LIBERTY TREE ACADEMY

TOWN OF PEYTON, EL PASO COUNTY
SITE DEVELOPMENT PLAN

SITE PLAN

Markup Summary

**SITE PLAN**

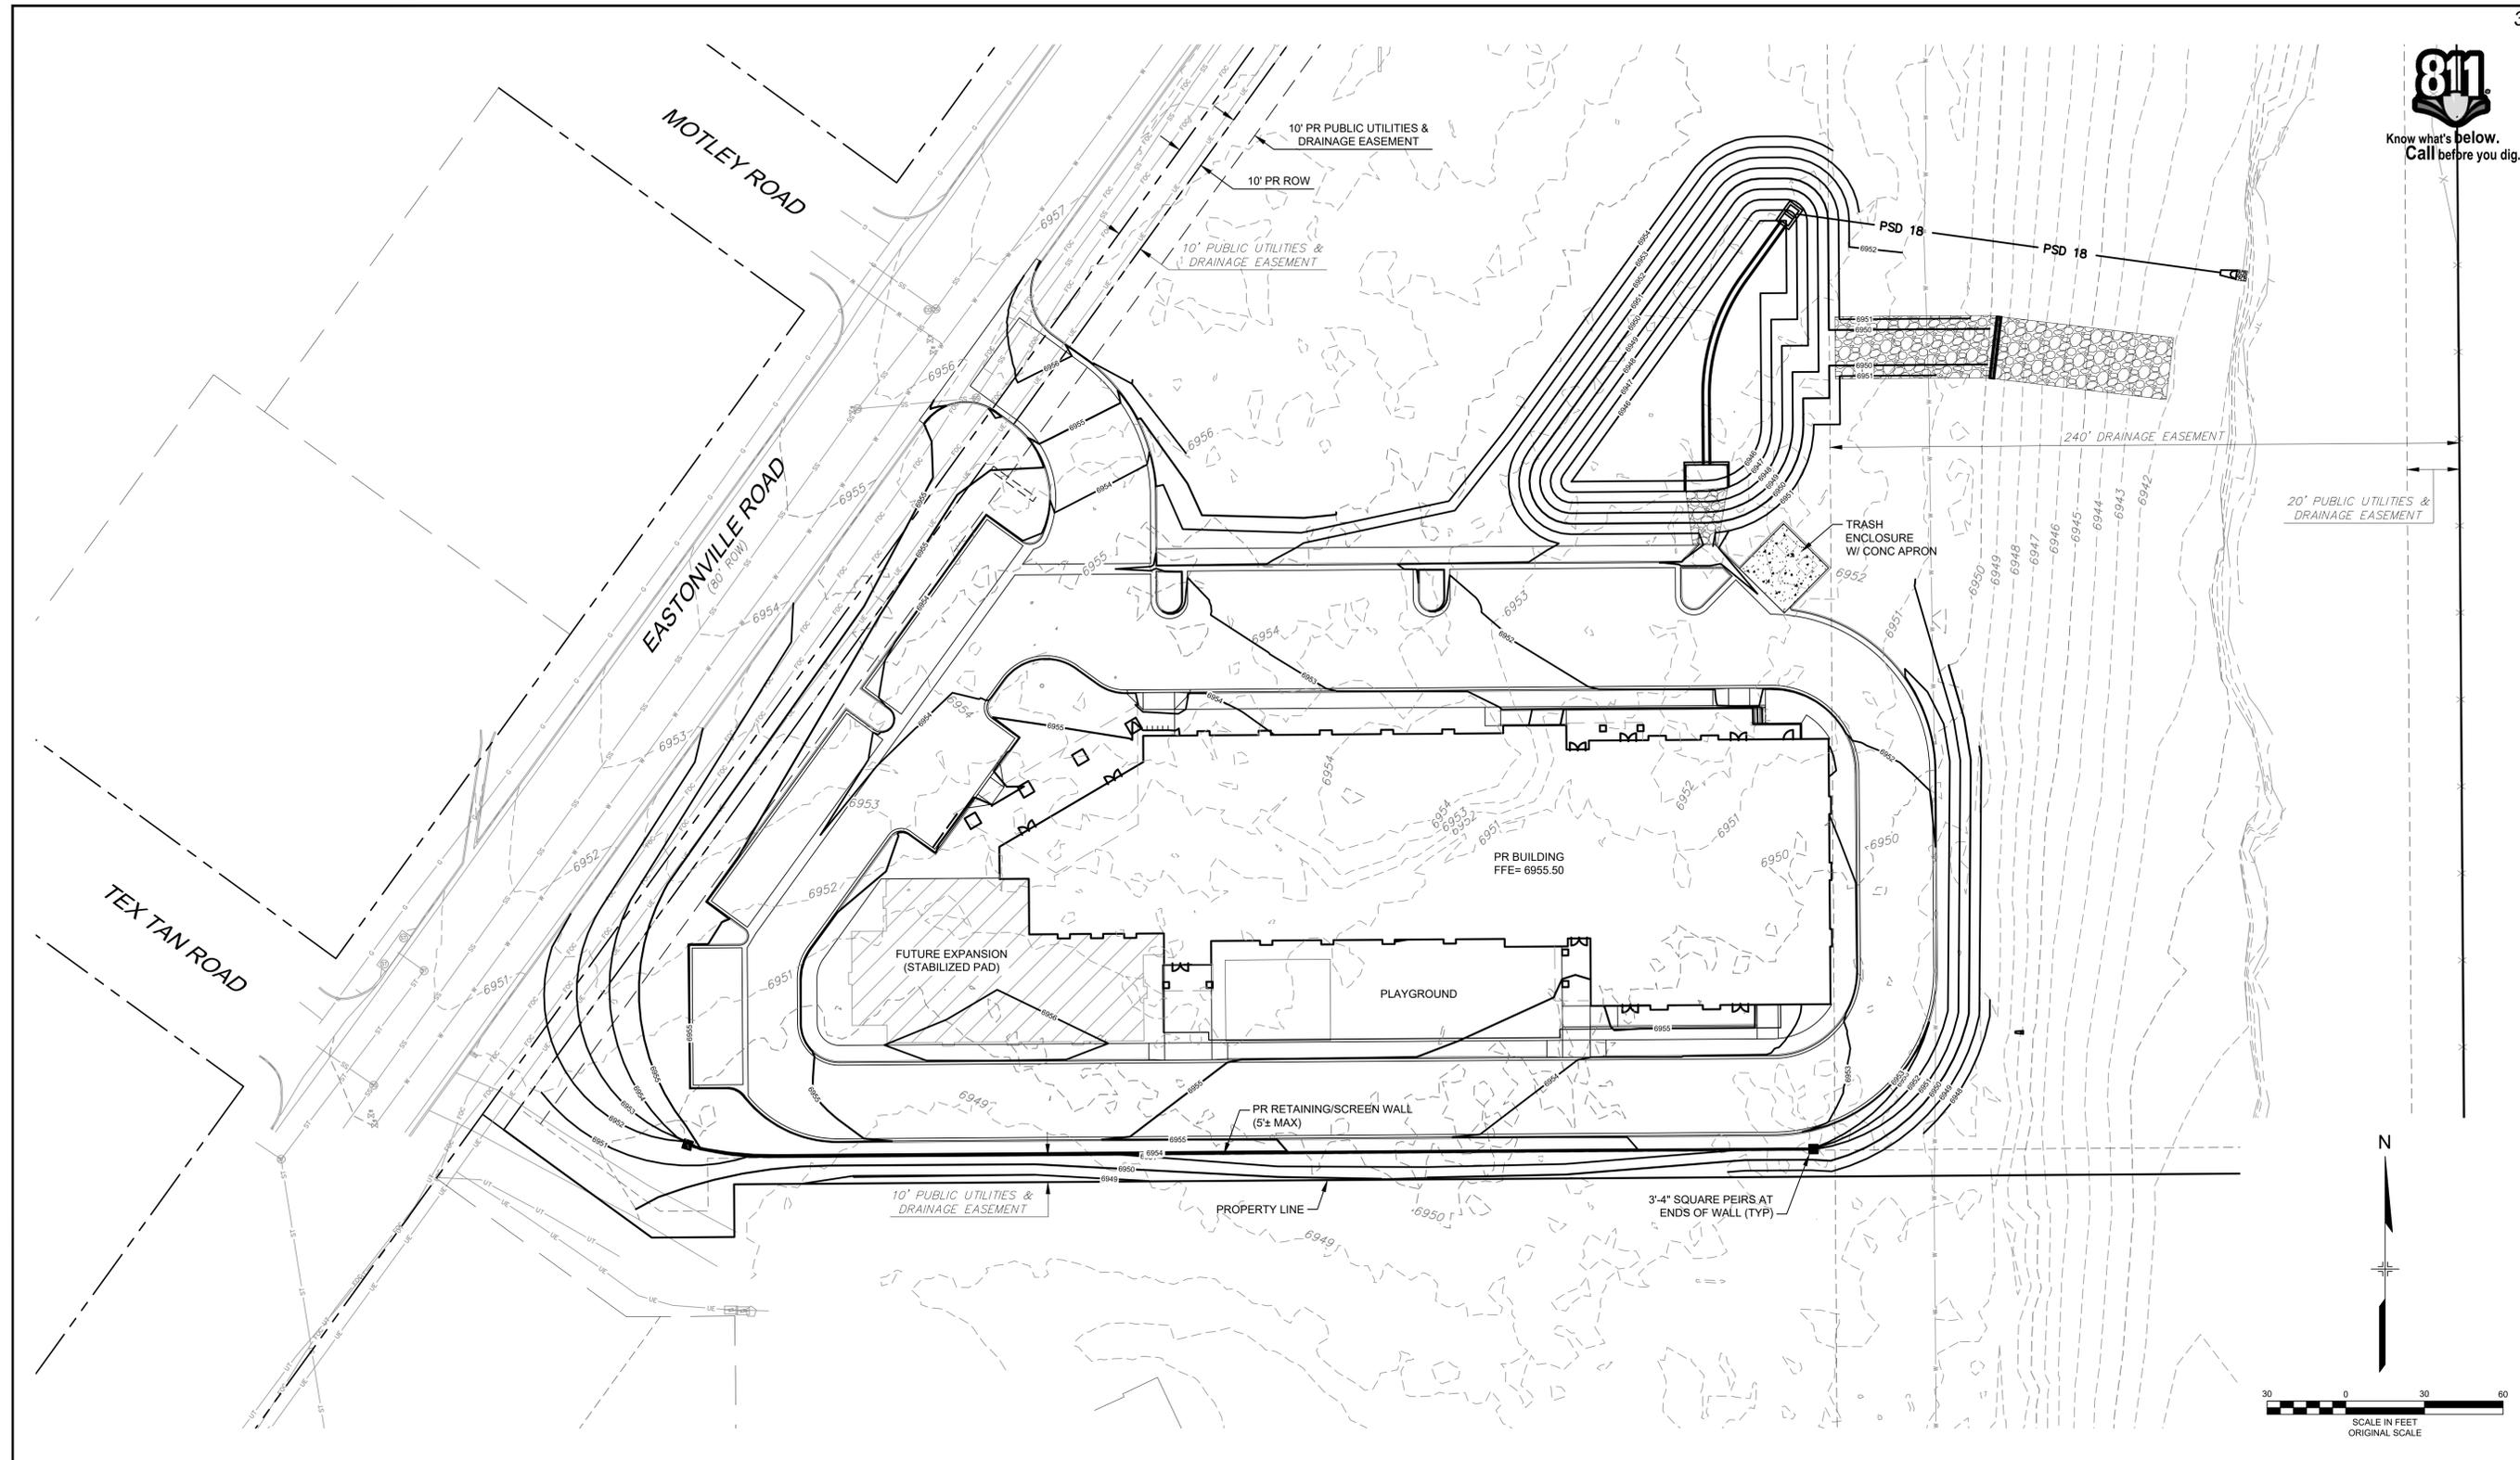
Show ADA Route to enter the structure from Parking spots.

Include a note stating that if and when the future expansion of a high school occurs the necessary parking required for a high school will be added to meet the parking regulations.

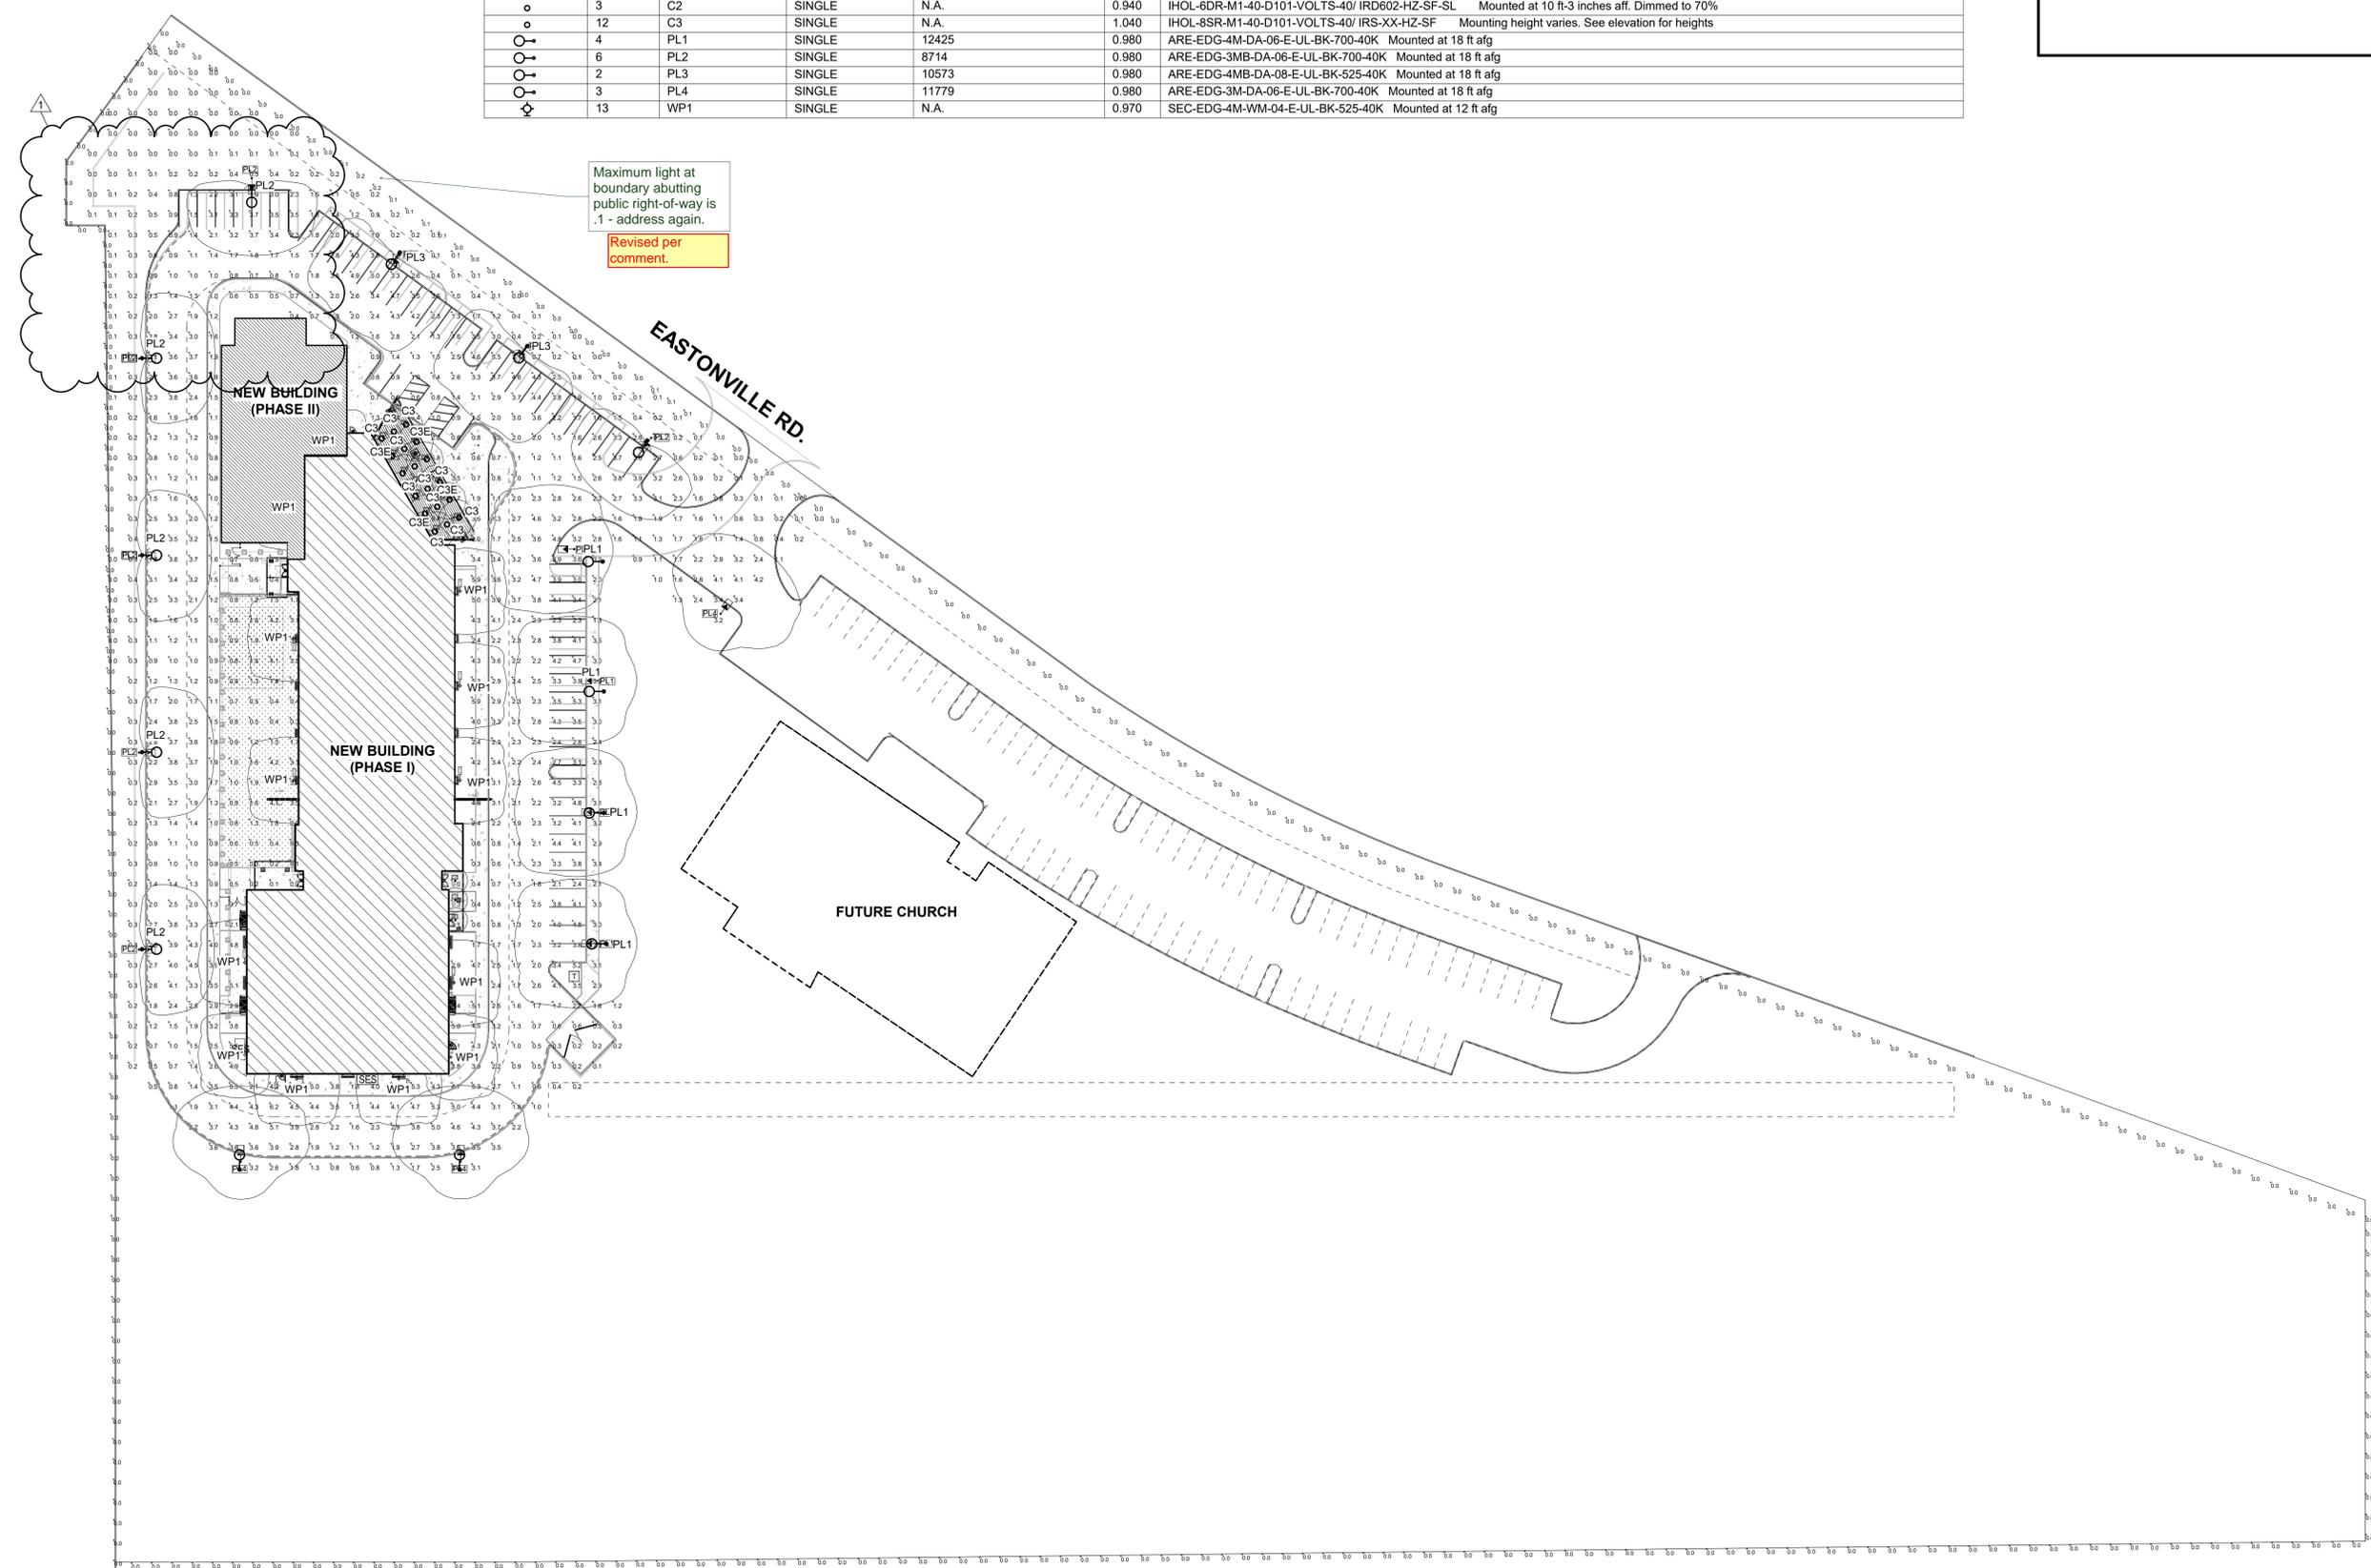
Maximum light at boundary abutting public right-of-way is .1 - address again.
